Our Ref: R/134/18/PL
Your Ref:

Town & Country Planning Act 1990 (as amended)
Town and Country Planning (Development Management Procedure) (England) Order 2015
Application for Planning Permission

Development 1 No. end of terrace two storey dwelling
Location 8 Duncton Road Rustington

Drawing P01      May 2018      Scale 1:100 @ A3  
Planning Drawing - Site Plan & Floor Plans

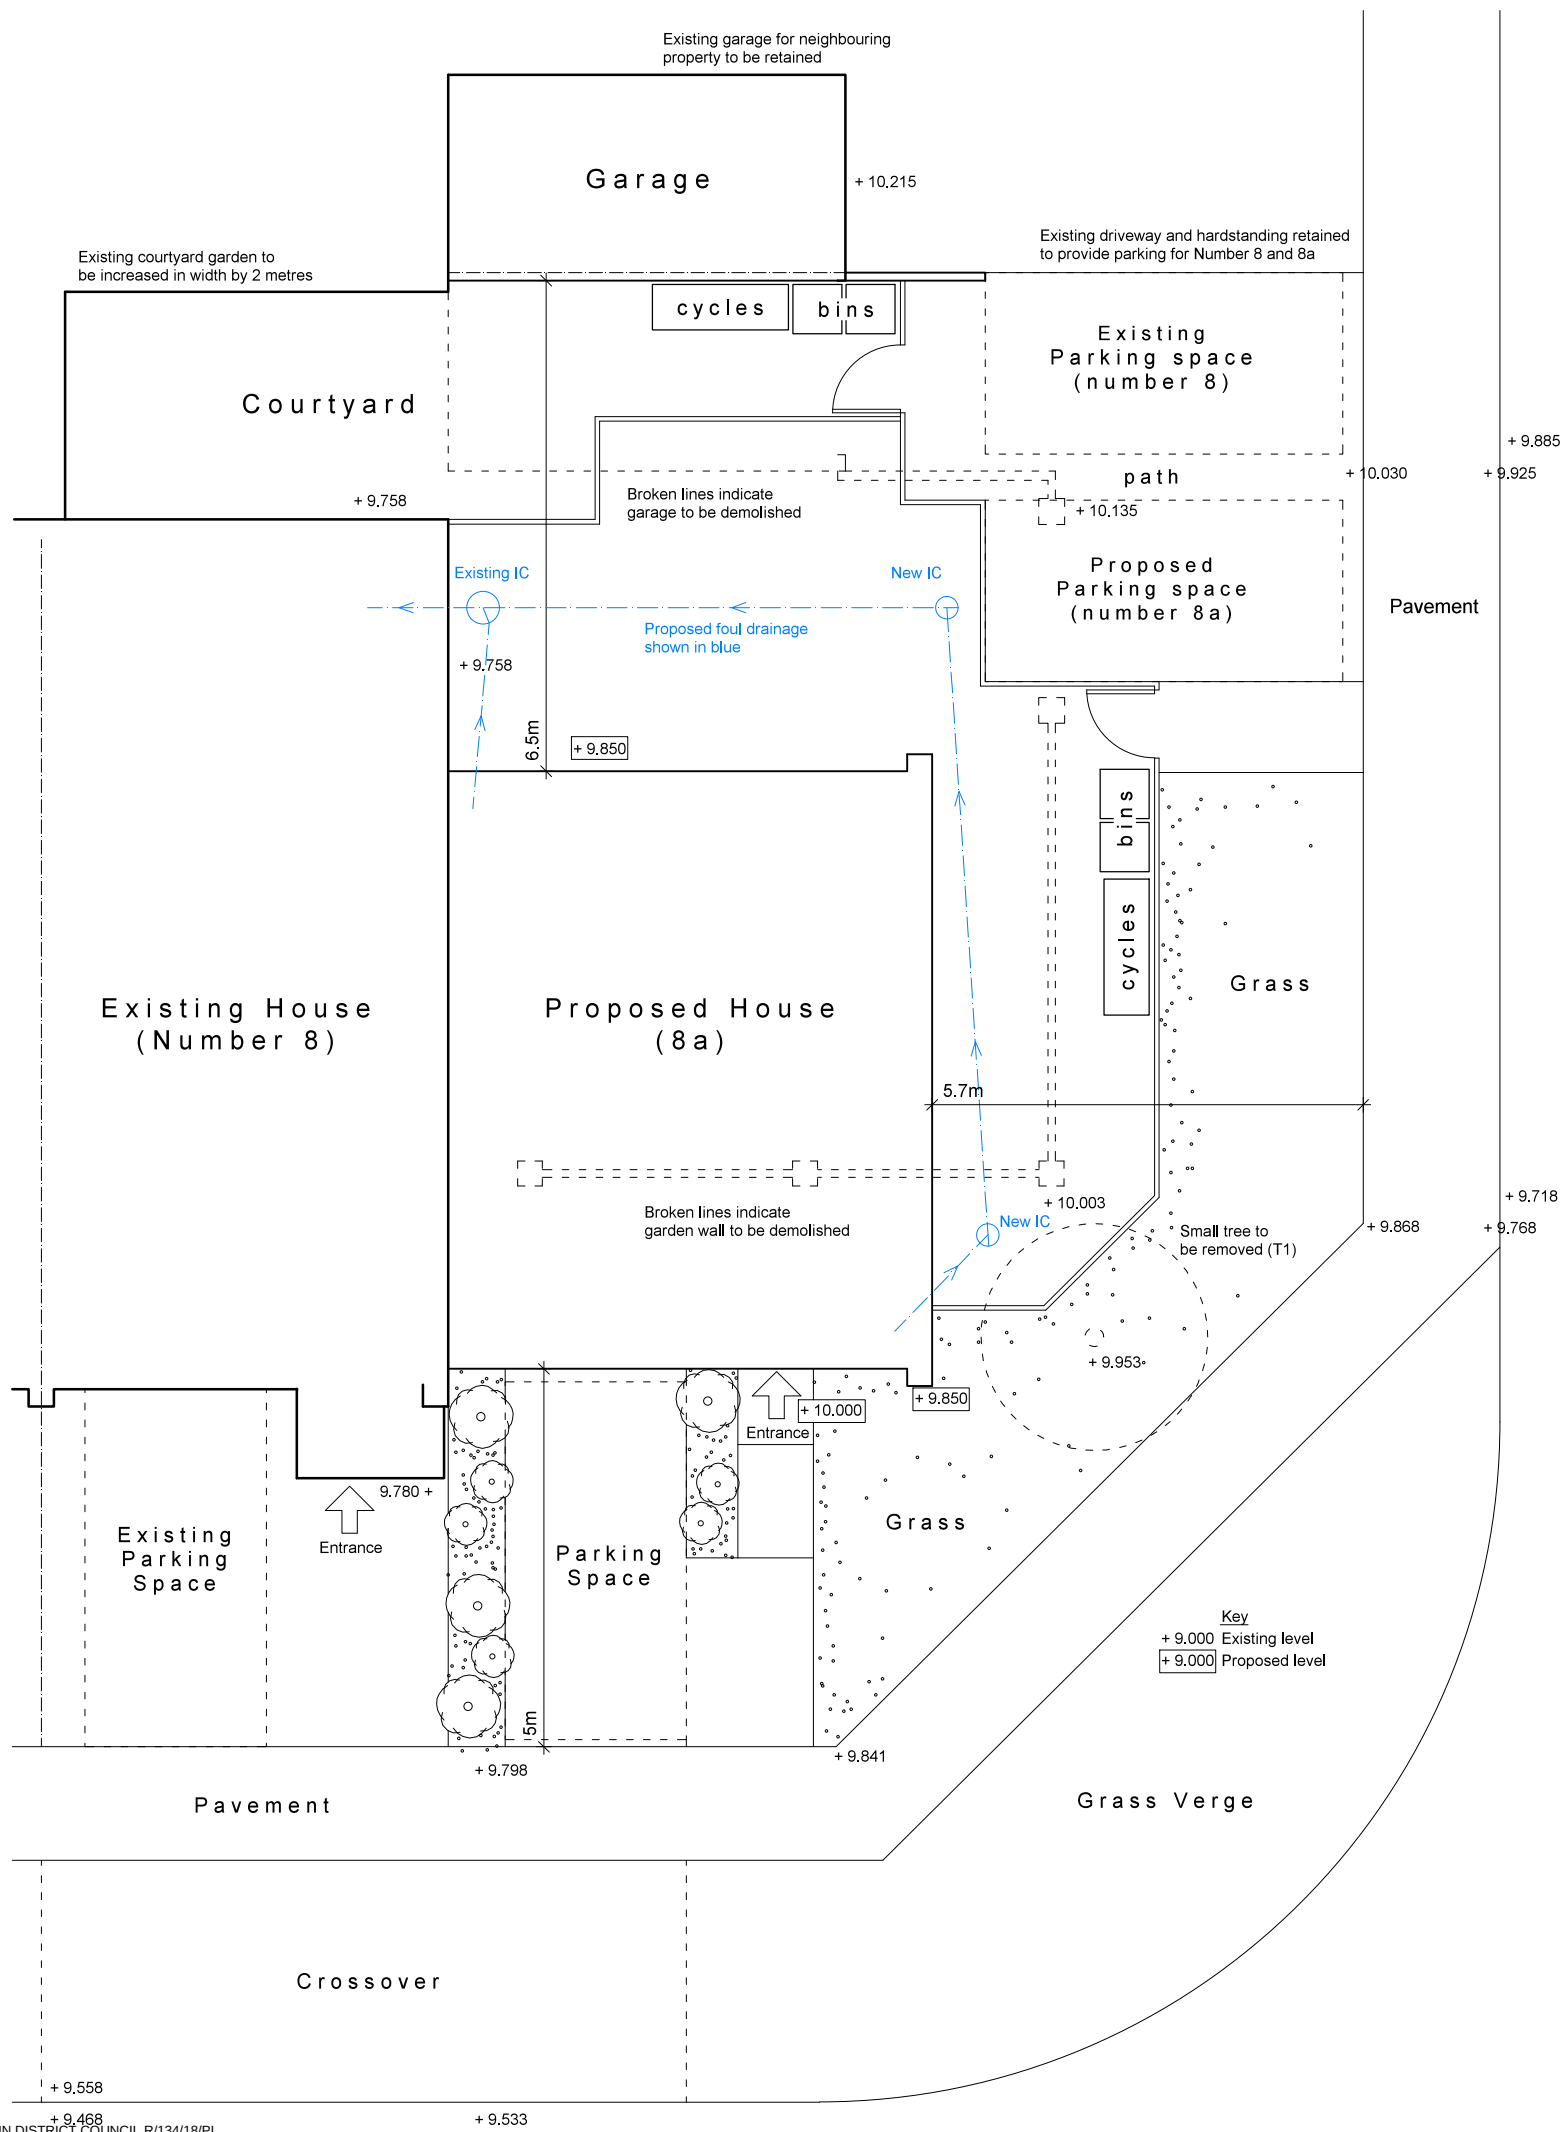
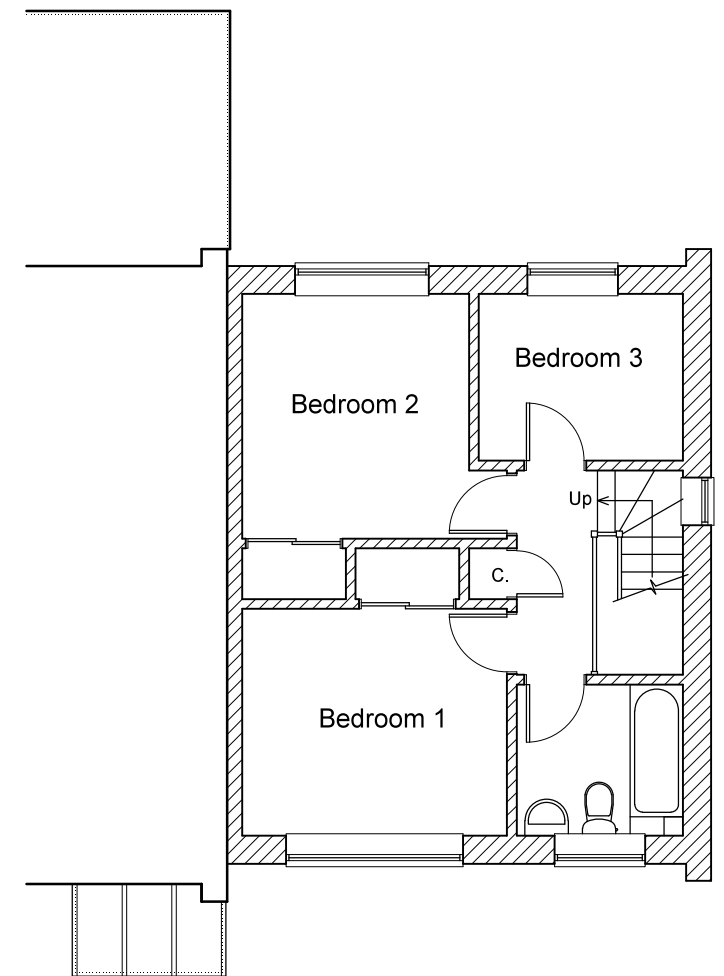
The proposed south first floor plan and elevation do not accord. Please amend accordingly.
